**FW: TfL Consultation response (app ref: 7969/APP/2024/2451) - The Barn Hotel**

**TfL Ref:** TFL/2026/1281

**LPA Ref:** 7969/APP/2024/2451

**Address:** THE BARN HOTEL WEST END ROAD RUISLIP

DETAILS Cycle & Refuse Stores

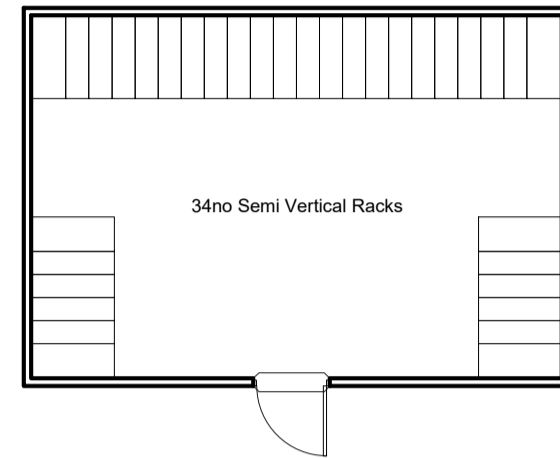
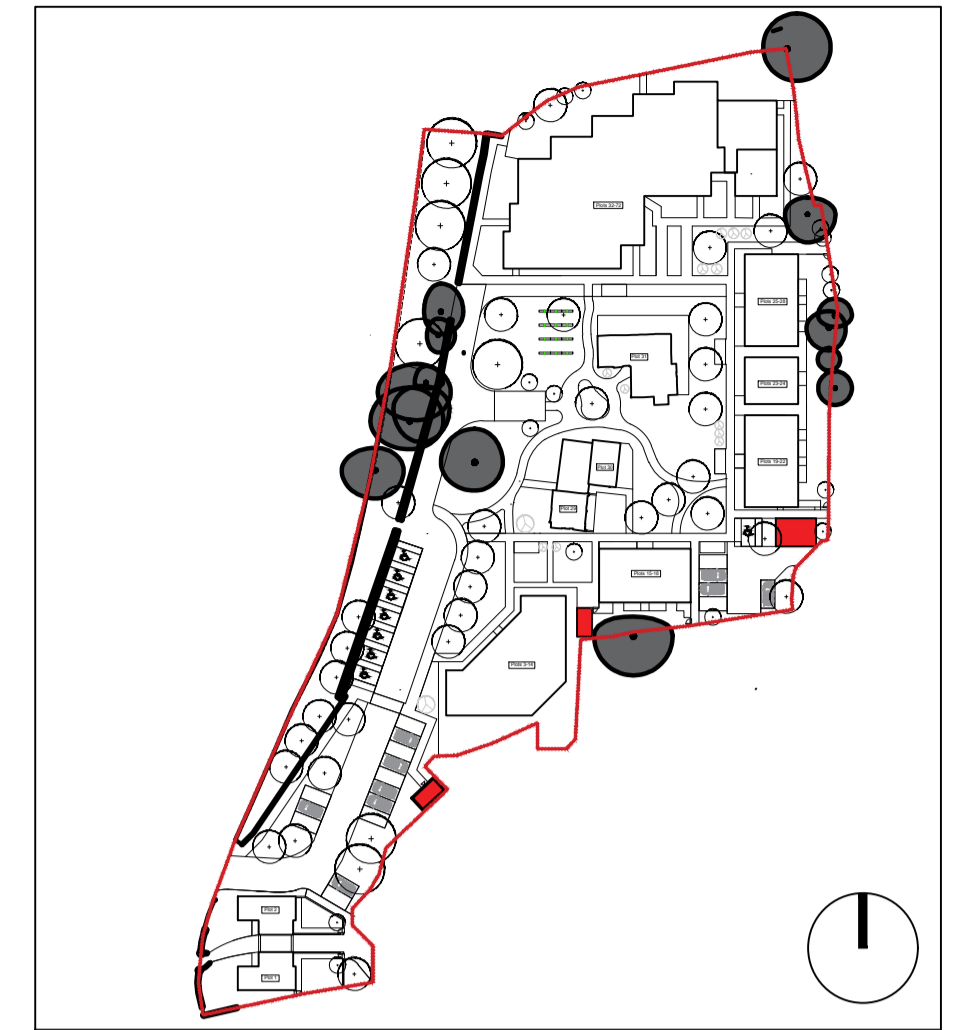
The proposed quantum of cycle parking complies with relevant London Plan standards. Clarifications on the store locations for each block is required, as well as the split of cycle parking stands including the minimum 5% of stands for adapted or larger cycles as required in the LCDS (London Cycle Design Standards). The applicant should provide detailed design drawings demonstrating compliance with LCDS, including layout, access routes, security, and usability. The distribution of cycle parking across the site should minimise travel distances and ensure convenient access for all units.
